From: Stuart Corbey
Sent: 20 February 2019 11:12
To: Karen Parsons
Subject: FW: EP/180/18/PL - The Boathouse, 131A Sea Road & Coastal Caravan Park

1. The site address. Please accept this is altered to 'Building West of 131 Sea Road, East Preston, BN16 1PD'
 - This is the land registry official address and for this application it needs to appear on a new set of yellow site notices to be erected for a further 21 days
2. When working towards the committee date of 10th April 2019, an extension of time up until the 12th April 2019 is sort.

- a) We need the location and block and caravan site plan numbered... (it's helpful if not essential)
- b) The term 'existing and proposed' need to be removed from all other plans - e.g. floor plans et al
- c) The flue added to all elevation plans (as current not shown)
- d) Confirmation that the plan listed as existing front elevation is omitted (as the building has been fully developed, therefore the plan is not relevant)
- e) Can you confirm the relevance of the section plan – demonstrating the concrete foundation – as this in our view can also be omitted if only applies to Building Regulations and thus not a planning matter.

Indicative Site Layout - Drawing No. 3

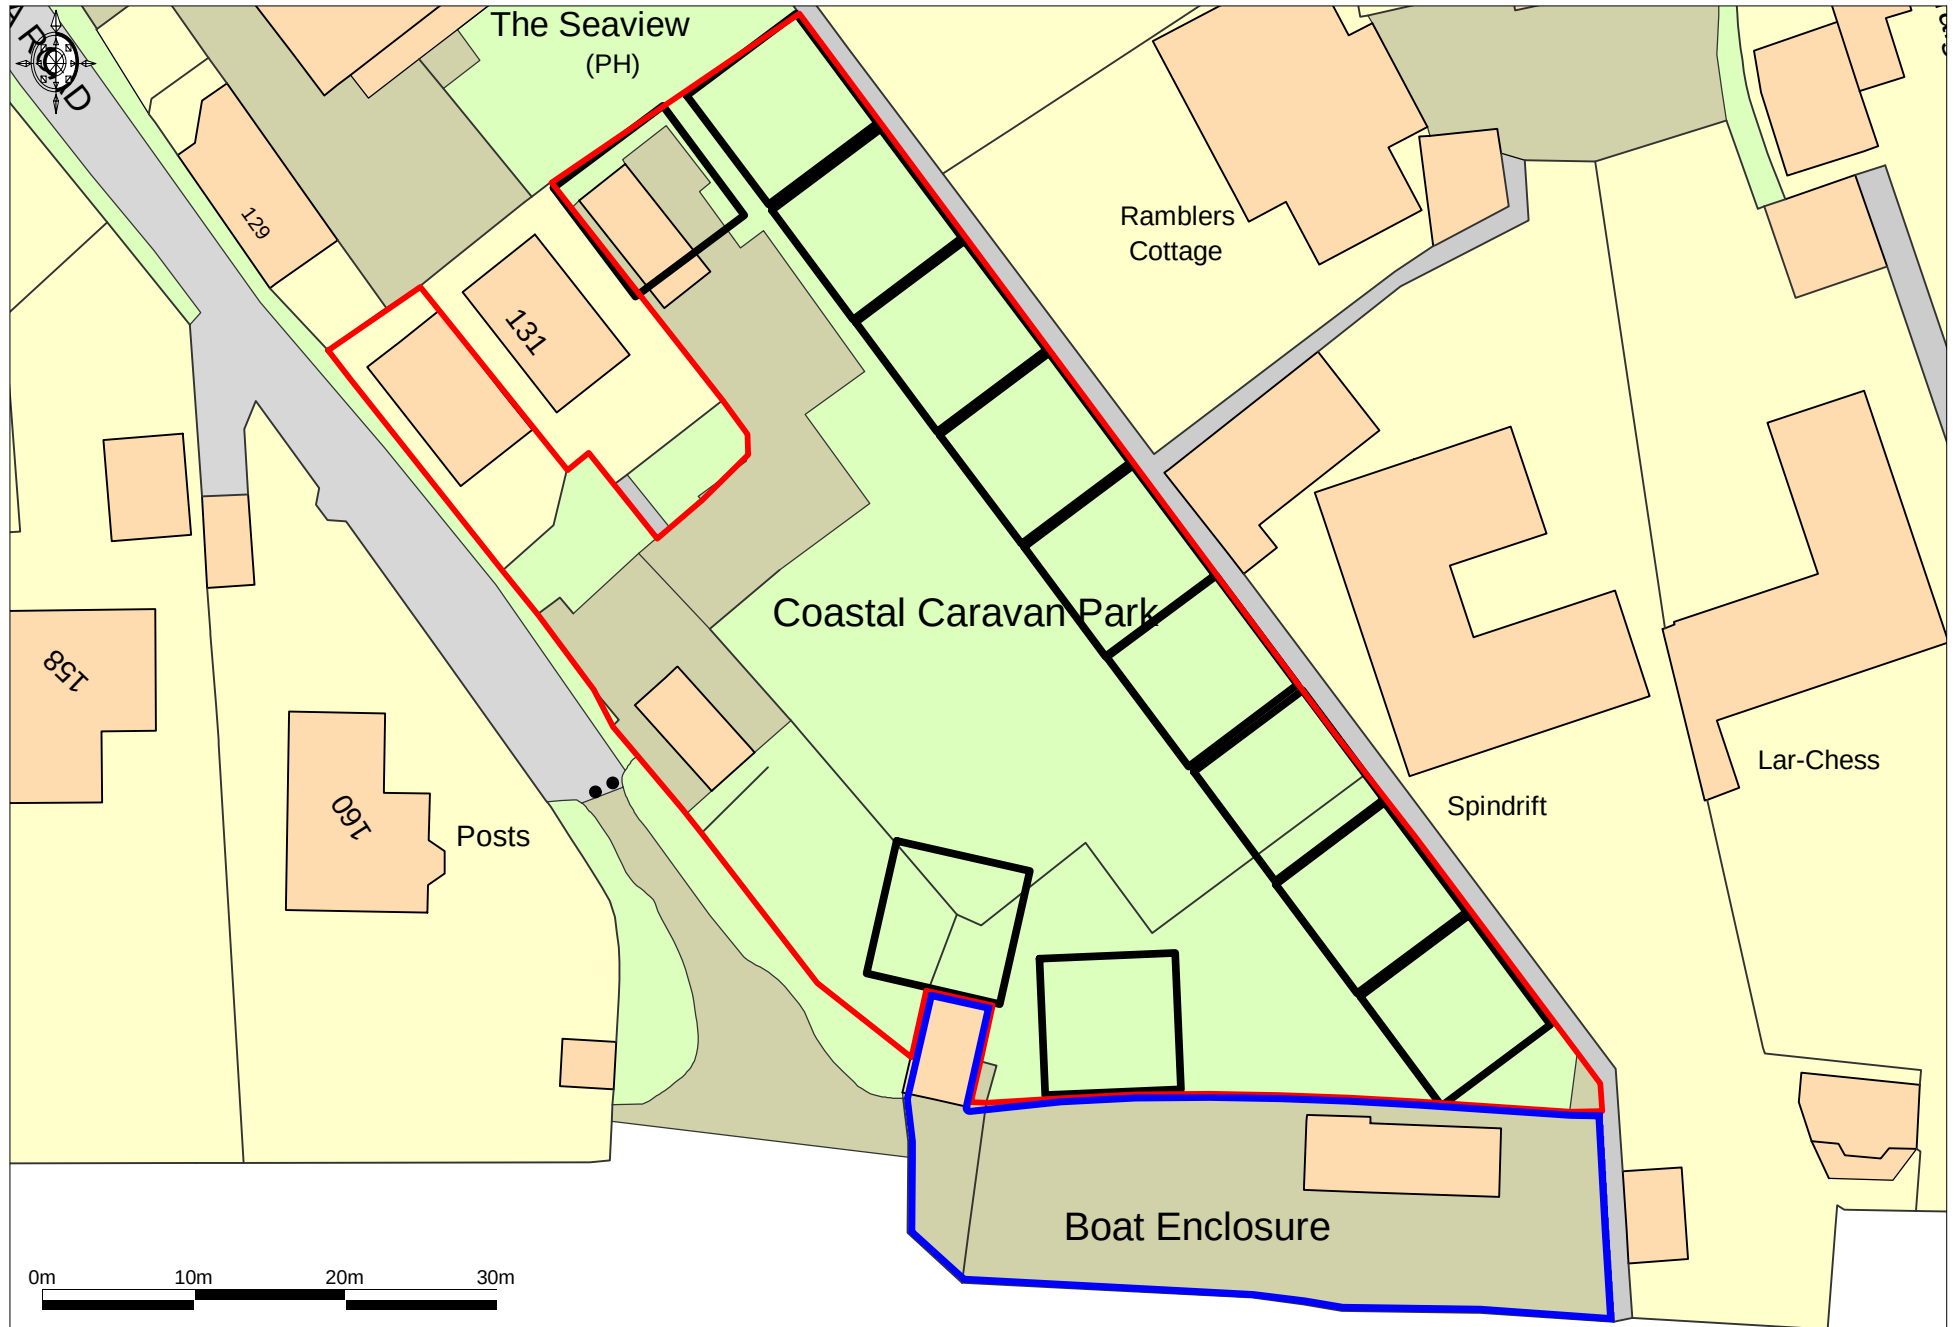
The plan as submitted to us on the 31st January 2019, shall be used as an additional plan, however, this will need to be updated and sent to us with a red line around the whole of the site to match that already submitted– (Proposed Extension to Caravan Park) plan.
